Our ref: Alterations and Additions to Barker College (SSD-31822612)

22 February 2023

Subject: Response to Submissions – Department’s Key Issues

FUTURE STAGES CONCEPT ENVELOPES

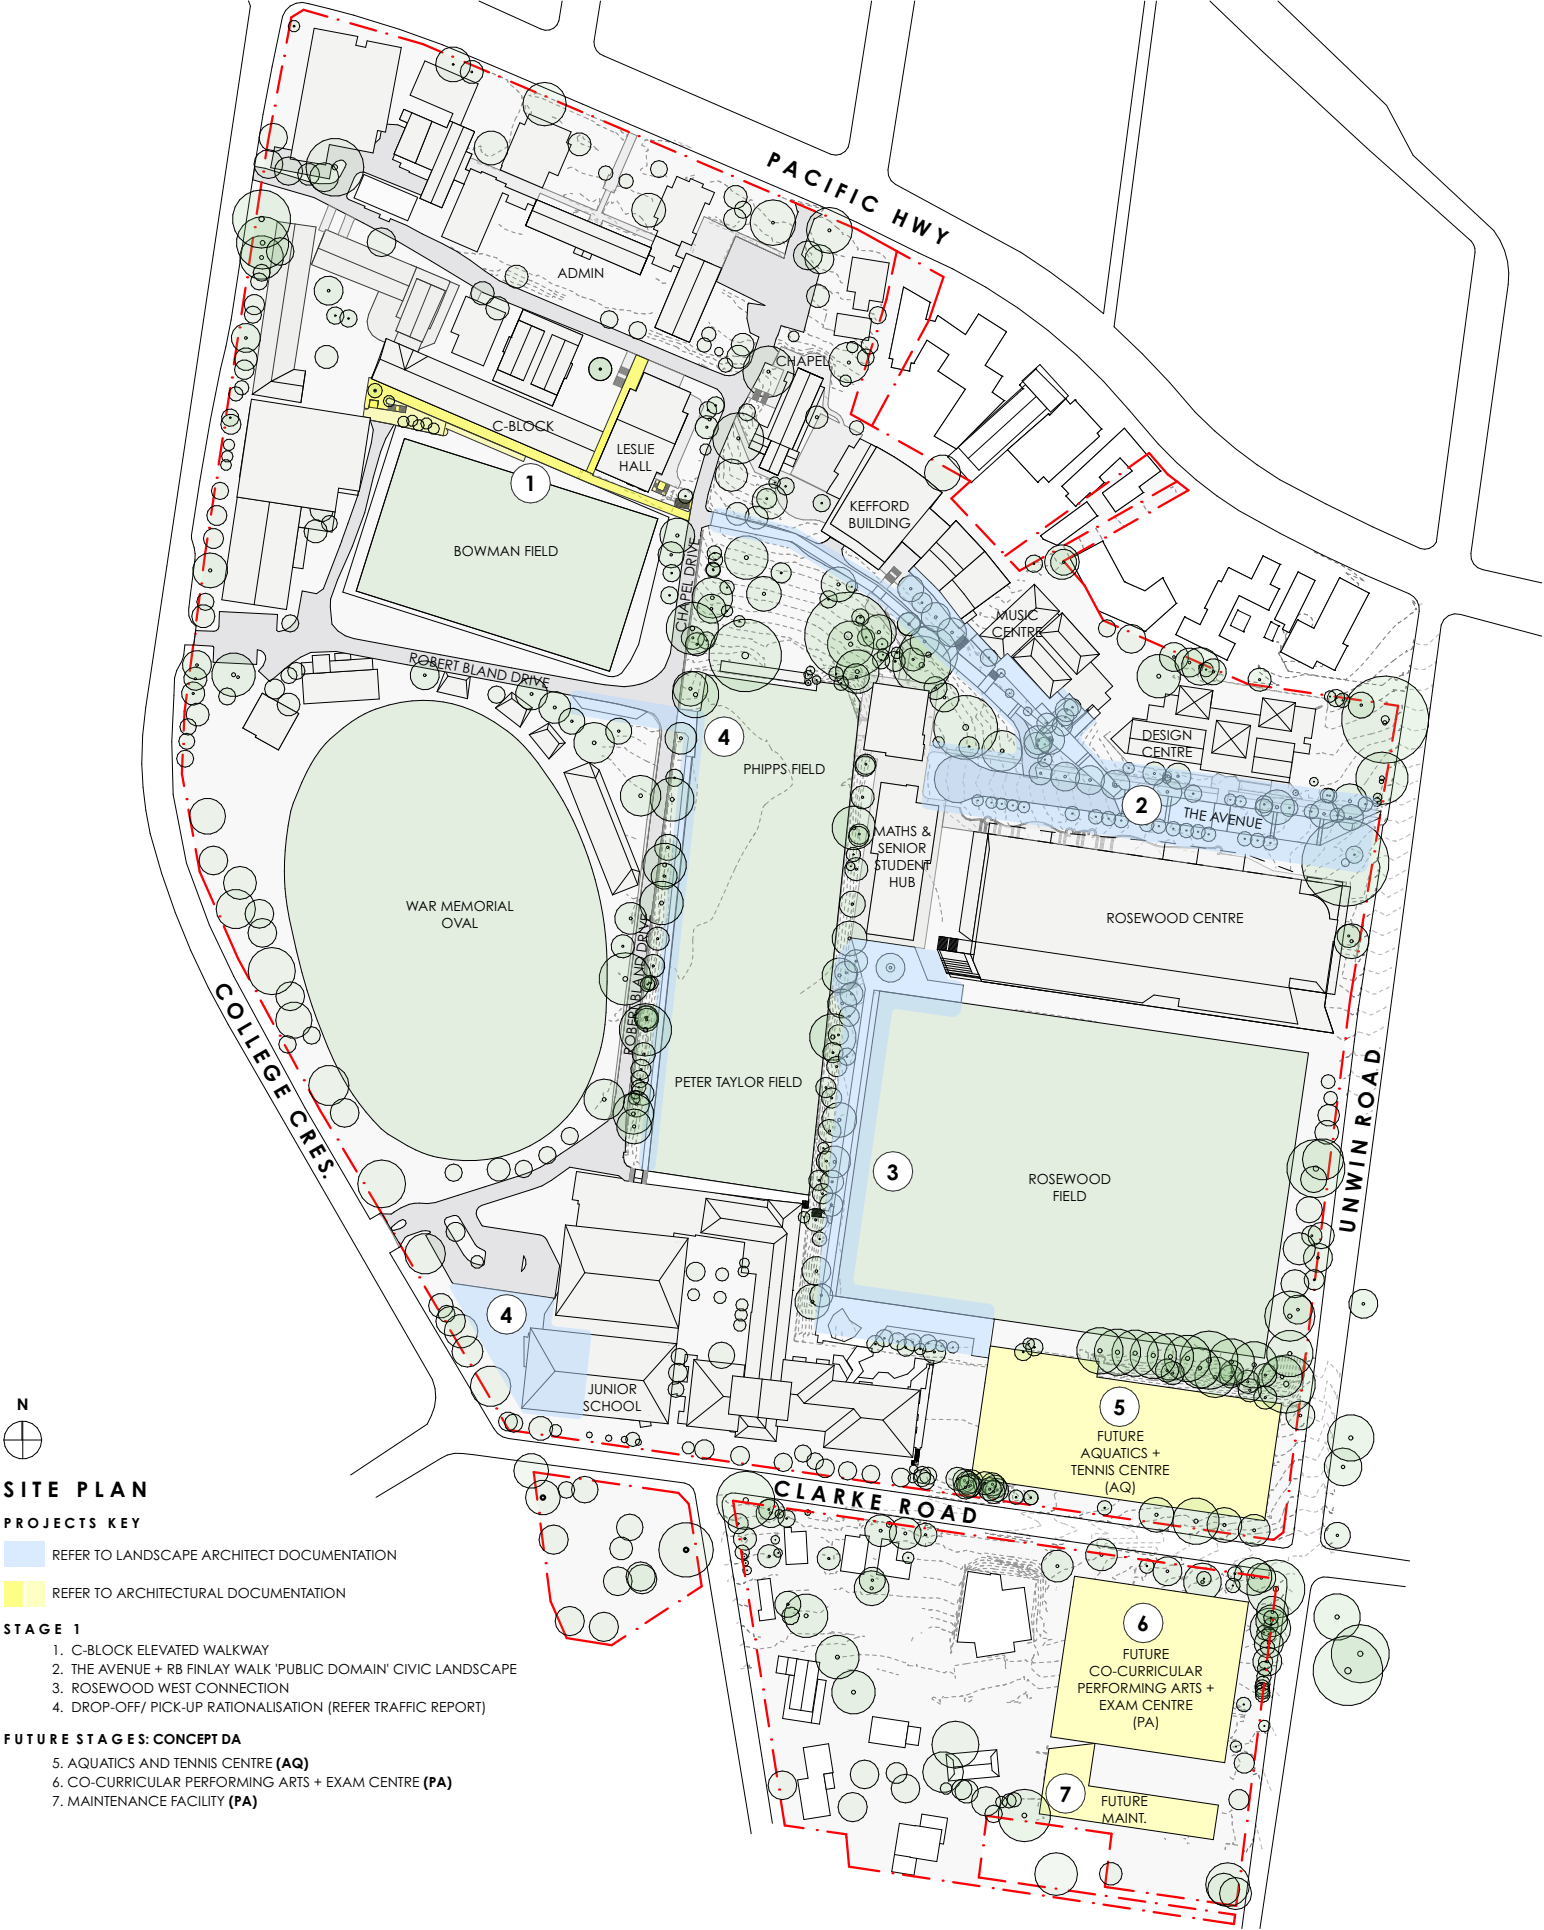
The proposed height of the Performing Arts and Exams centre (PA) and Aquatic and Tennis centres (AT) exceed the maximum height limit of 8.5m under the Hornsby Local Environmental Plan (HLEP) by approximately 103% (17.3m max height for PA) and 110% (17.95m for AT centre), respectively. The EIS justifies the exceedance in height by stating that the building envelopes are consistent with other similar school buildings on the site and that strict compliance with the height limit would lead to a suboptimal planning outcome, given the functional requirements of the school. Furthermore, the EIS states that the proposed building envelopes provide appropriate landscape setbacks to offset the exceedance in height.

The Department notes that reference designs have been provided in the Design Report which identify that the main reasons for the height exceedances are related to the tennis court nets (for AT) and the plant rooms (for PA). The EIS justifies that the exceedances in heights are appropriate. However, the Department considers that further justification would be required to demonstrate that the building envelopes fit in the context of the existing school buildings within the site as well as with the surrounding low density character of Unwin Road and Clarke Road. In this regard, the Department requires you to provide:

- additional design guidance (in the Design Report) or concept diagrams demonstrating how façade articulation would be achieved along Clarke and Unwin Roads for both the PA and AT facades, to reduce the overall building bulk. This may include stepping the buildings to reduce the perceived height from the public domain (especially along Unwin Road).
- design options that would result in reduction of the building heights through alternative designs for the rooftop plant (PA) and/or the tennis court nets (AT).

- additional mitigation measures to reduce impacts of the building bulks (for PA and AT) on the existing visual environment. These may include (but not be limited to) landscape treatments within setback areas, increasing the setbacks from Clarke Road and/or Unwin Road, further height modulation and building articulation.
